Our Ref: R/2020/17/A
File No: 2022/059877
Your Ref: SSD-12618001

Request for Advice – 104-116 Regent Street, Redfern – Student Accommodation (SSD-12618001)

Notwithstanding the above, the **City has reviewed the accompanying documentation and objects to the proposal** in its current form based on the following matters:

1 Margaret St Elevation
Elevation 1 : 200

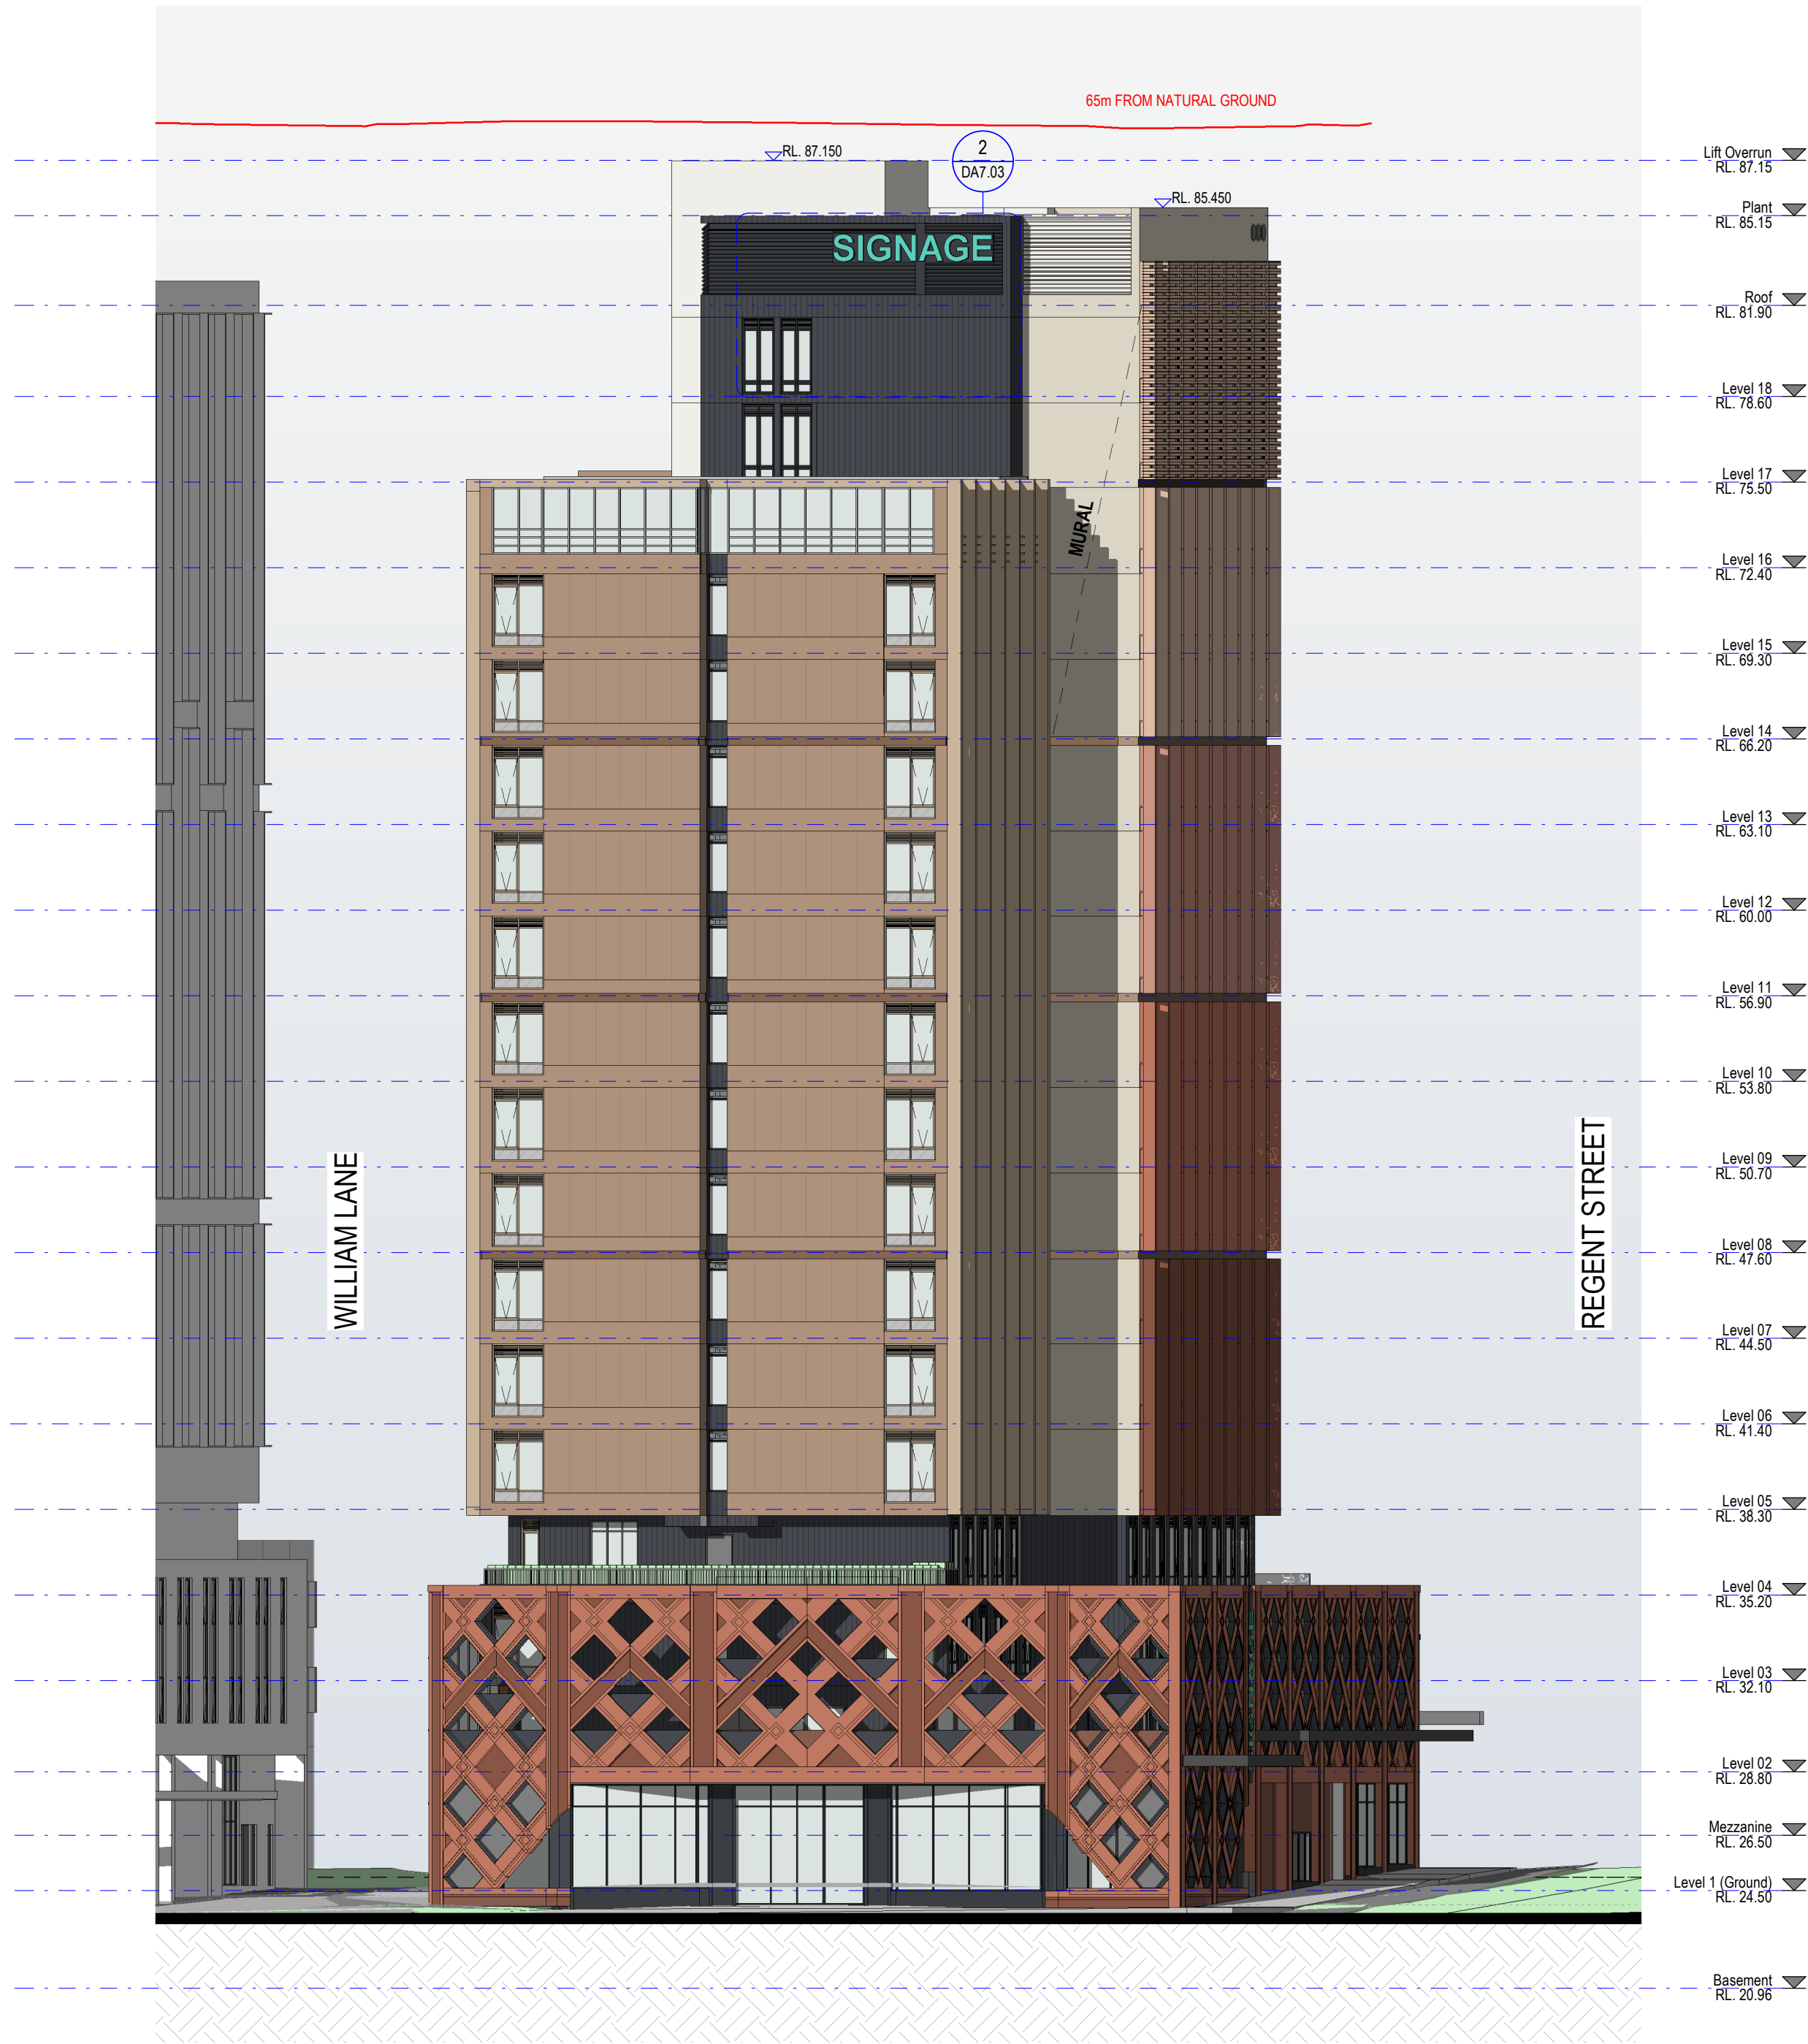
The Margaret Street facade includes a recessed secondary entry, which sits in an undercroft of the podium. This fails to positively reinforce the street edge, would receive no natural light due to its orientation, and creates CPTED concerns for both residents and the public. The through site link facade also includes large areas of services with no entry point for activation.

DRAWING TITLE
Northern Elevation + Southern
Elevation

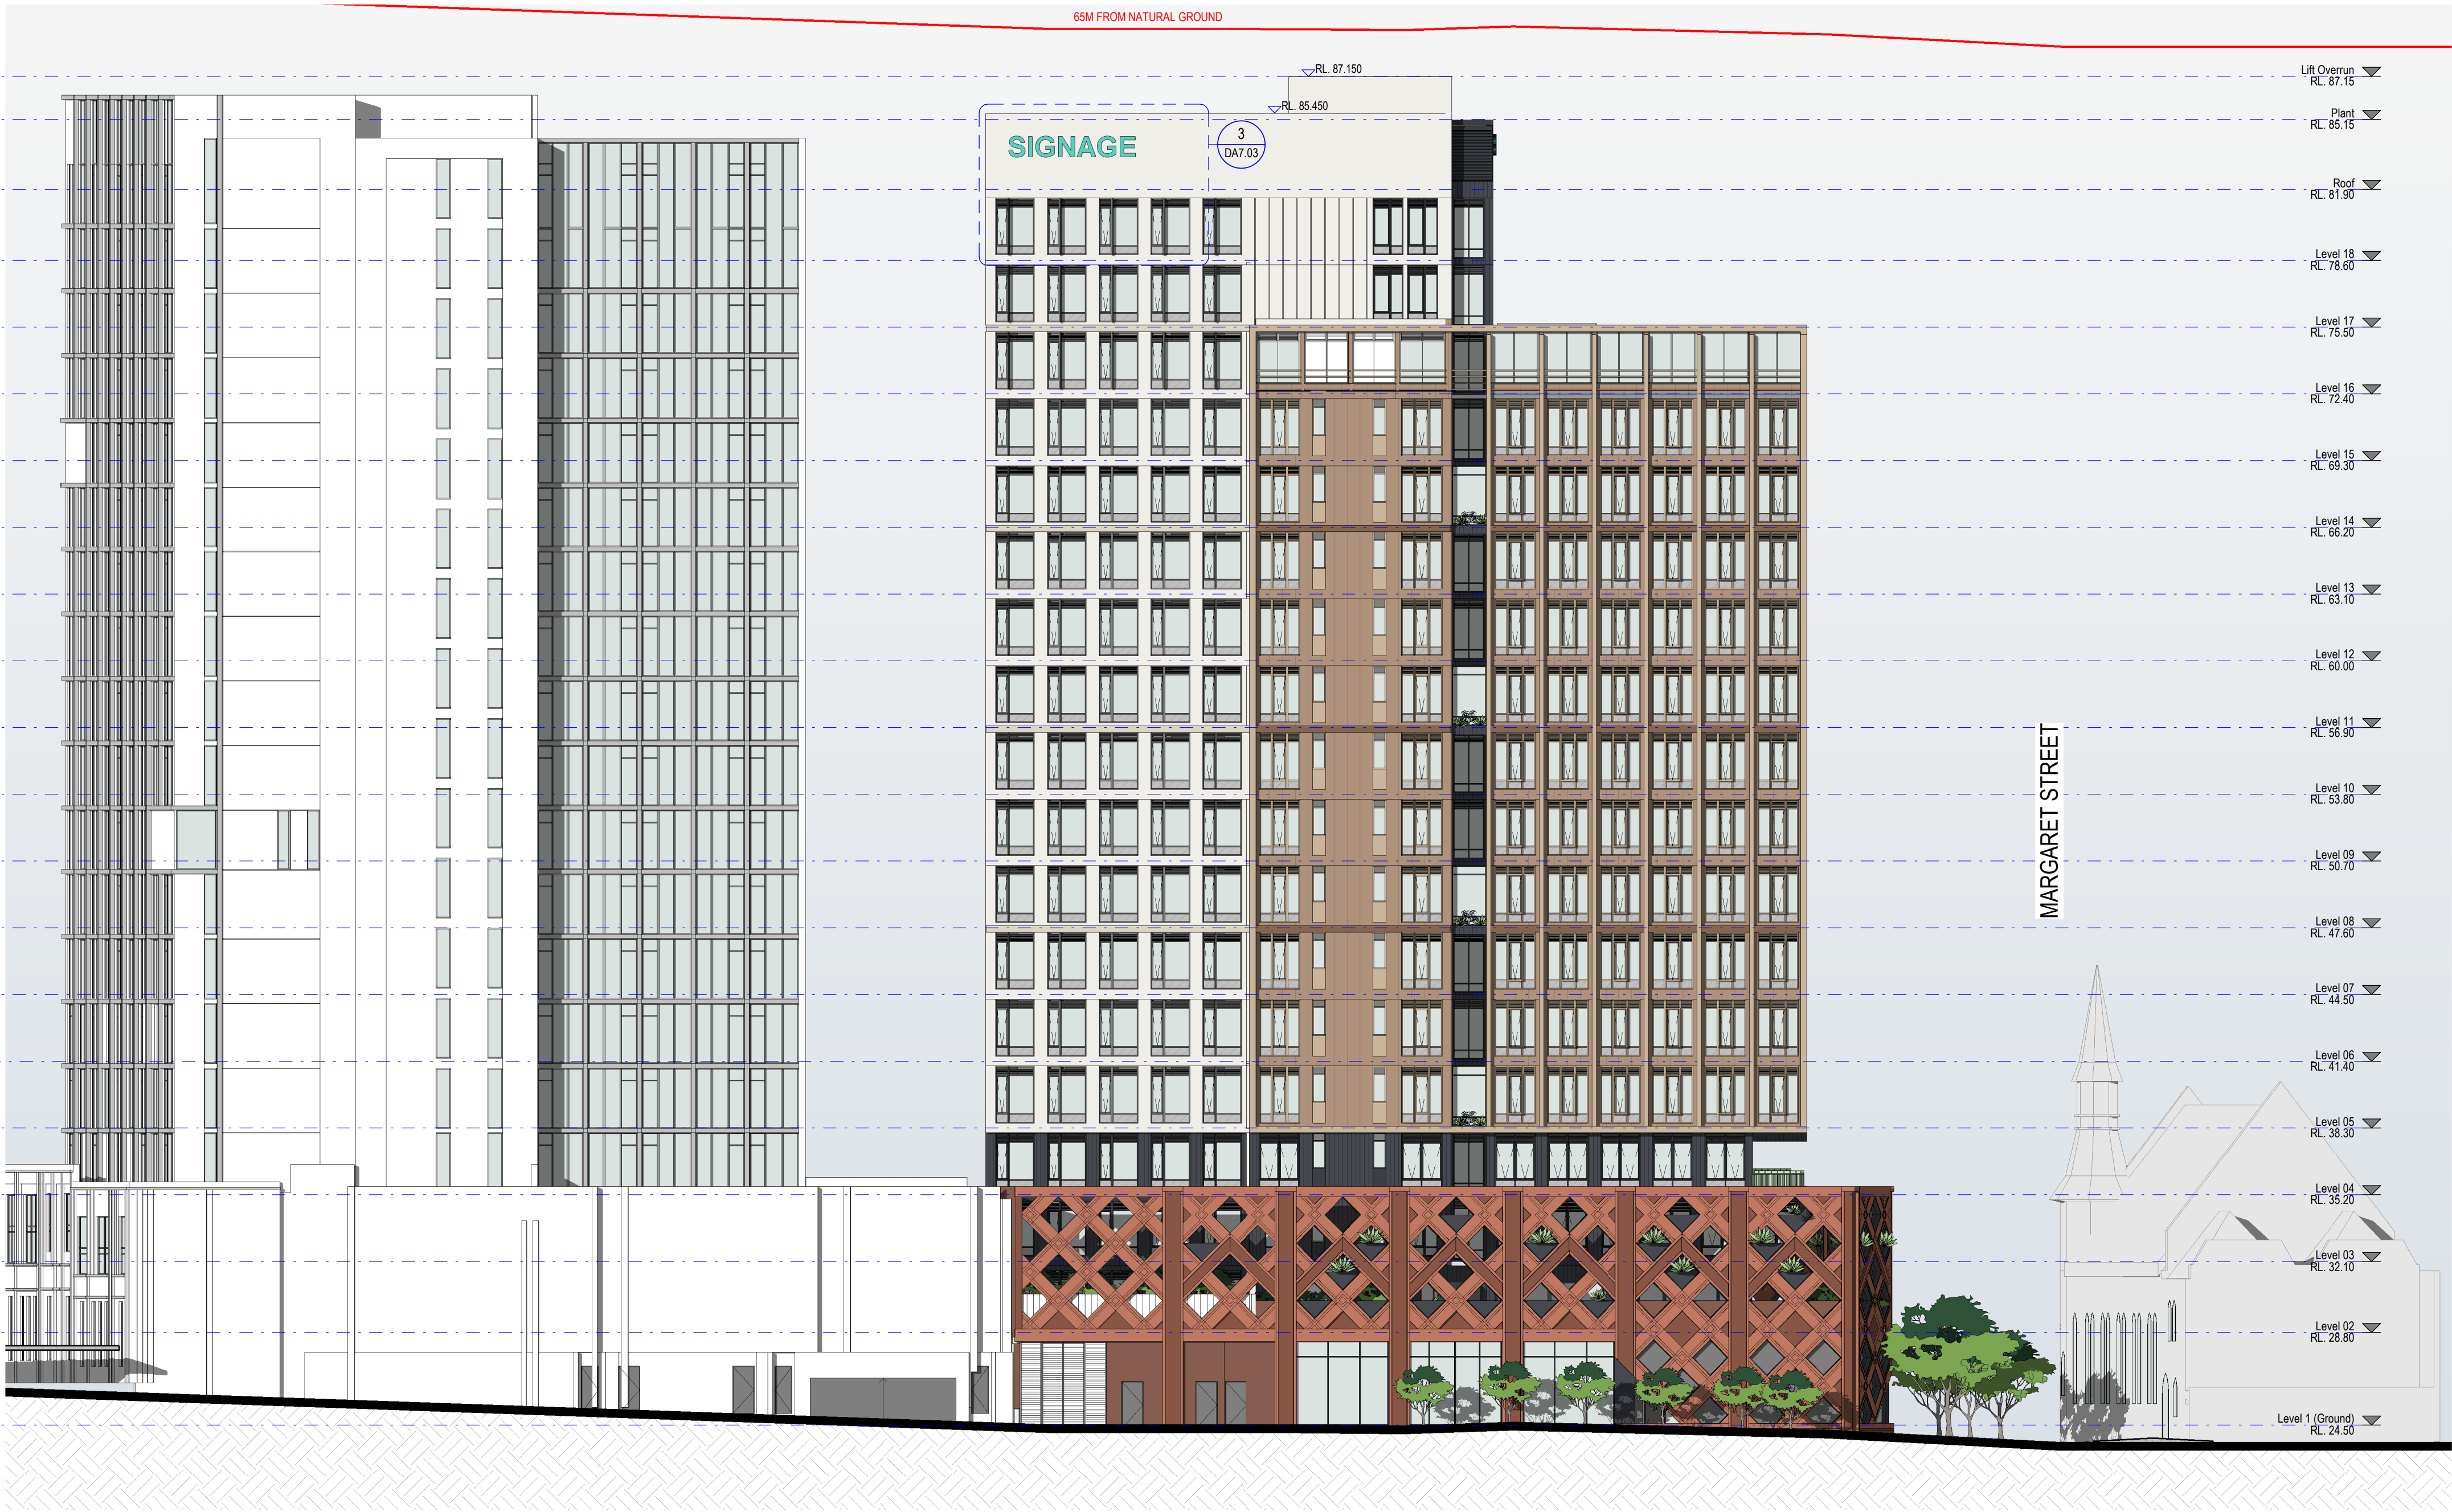
The proposed development presents large expanses of tower to the south and north which are of plain paint finish walls. The site will be the terminating tower of the block, which transitions to much lower scale development to the south. Therefore, the southern tower walls will be highly visible from multiple long views for the long term and as proposed, do not demonstrate design excellence in architectural design. The building needs to architecturally address the corner, provide greater articulation, and propose improved materiality to the south and the possible incorporation of public art.

Similarly, the northern tower parapet and plant room wall treatment are a painted finish, which appear unintegrated with the tower and are not of high quality. The RCUDP skyline and rooftop design provisions regarding roof

The City recommends that an improved design, articulation, materiality and public art be considered to all south and north facing tower walls that are indicated as paint finish as well as to the paint finish walls at Levels 3 and 4. Further details is requested in the form of 1:20 wall sections and elevations detailing the brick and construction elements of the podium and screen. The quality, materiality and finishes of all ground level services is recommended to match the façade quality and not be the contrasting paint finish to the brick colour.
